Reinforcement to North Shropshire Electricity Distribution Network by SP Manweb

Local Impact Report of Shropshire Council - March 2019

VIEWPOINT 08: THE MONTGOMERY CANAL / THE SHROPSHIRE WAY TRAIL (VIEW NORTH)

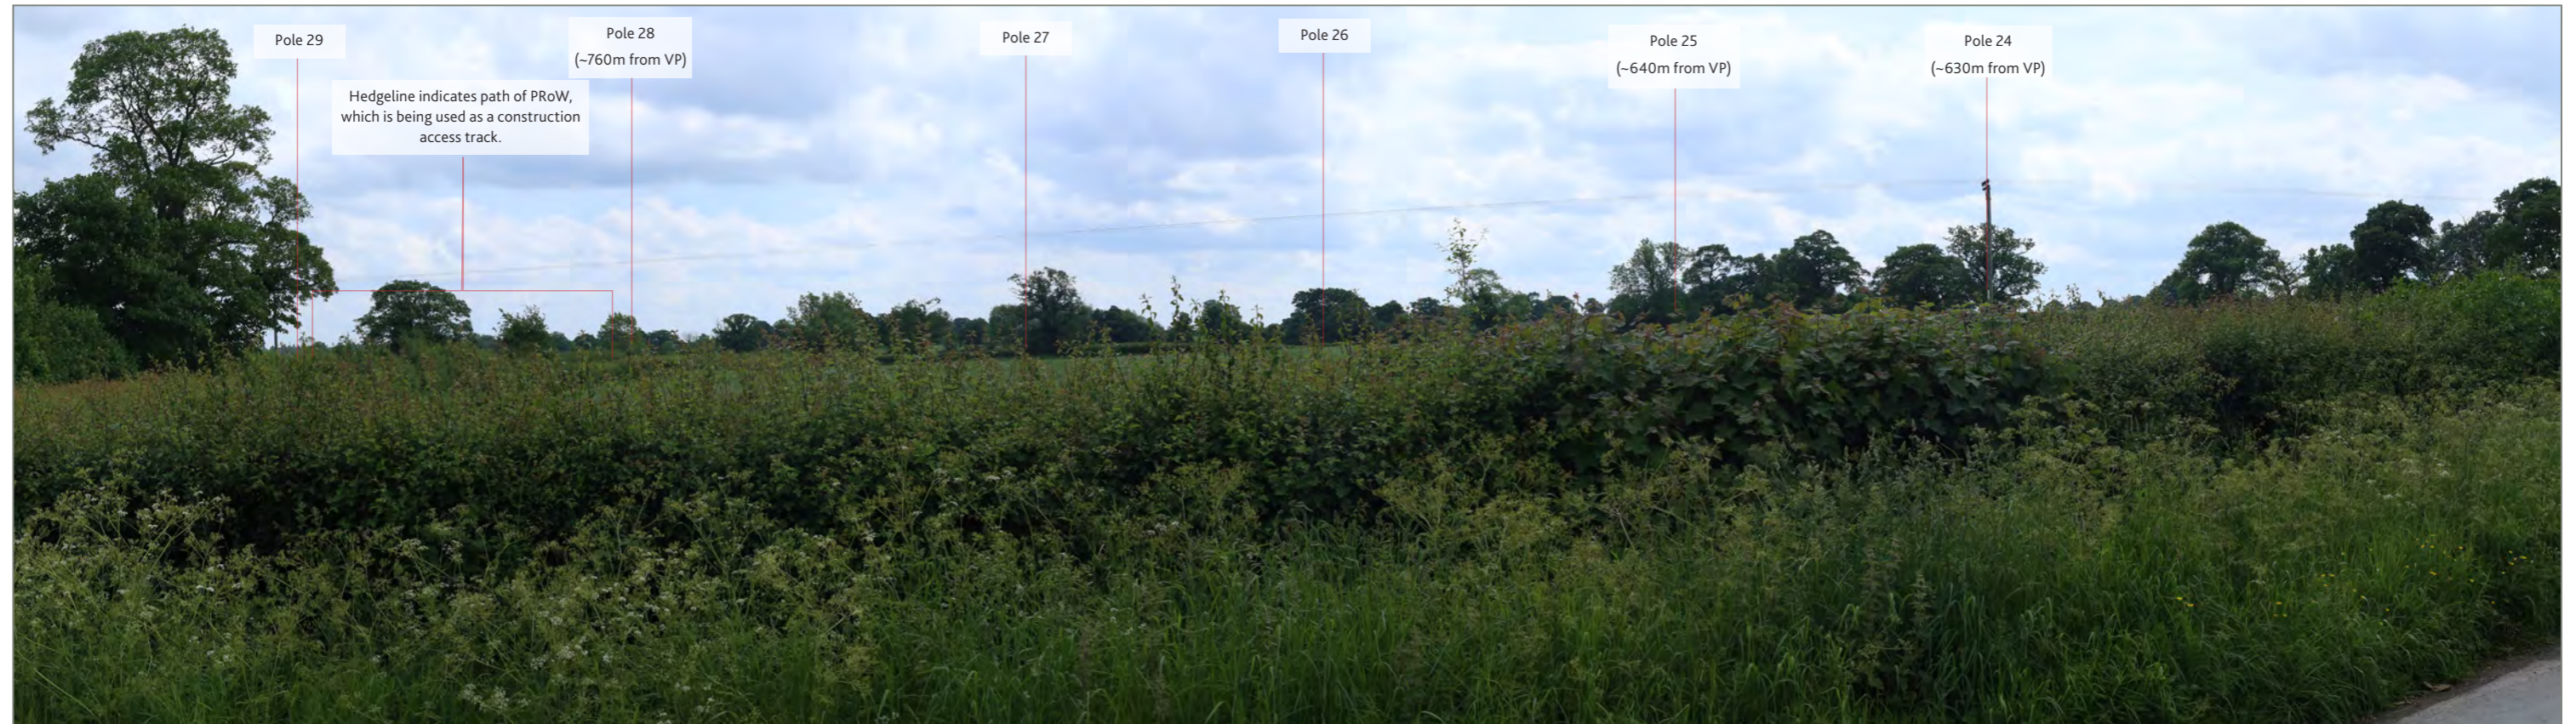
- 5.16 The Council and its landscape consultant expressed some concern during their review of the PEIR that the proposed viewpoint no. 8 did not fully consider the visual effects that might be experienced by users of the Montgomery Canal which forms part of the Shropshire Way at this point and who are likely to have an enhanced sensitivity to visual change. Viewpoint no. 9 in the ES includes an additional assessment so that the ES now assesses the predicted visual effects of the Proposed Development in the vicinity of the Montgomery Canal from both the north and south and predicts a level of effect at construction and operation as minor or negligible adverse (not significant). It is considered the level of assessment of visual effects in this location, along with viewpoint no. 10 to the north, is of assistance in addressing the concerns that have been raised by the
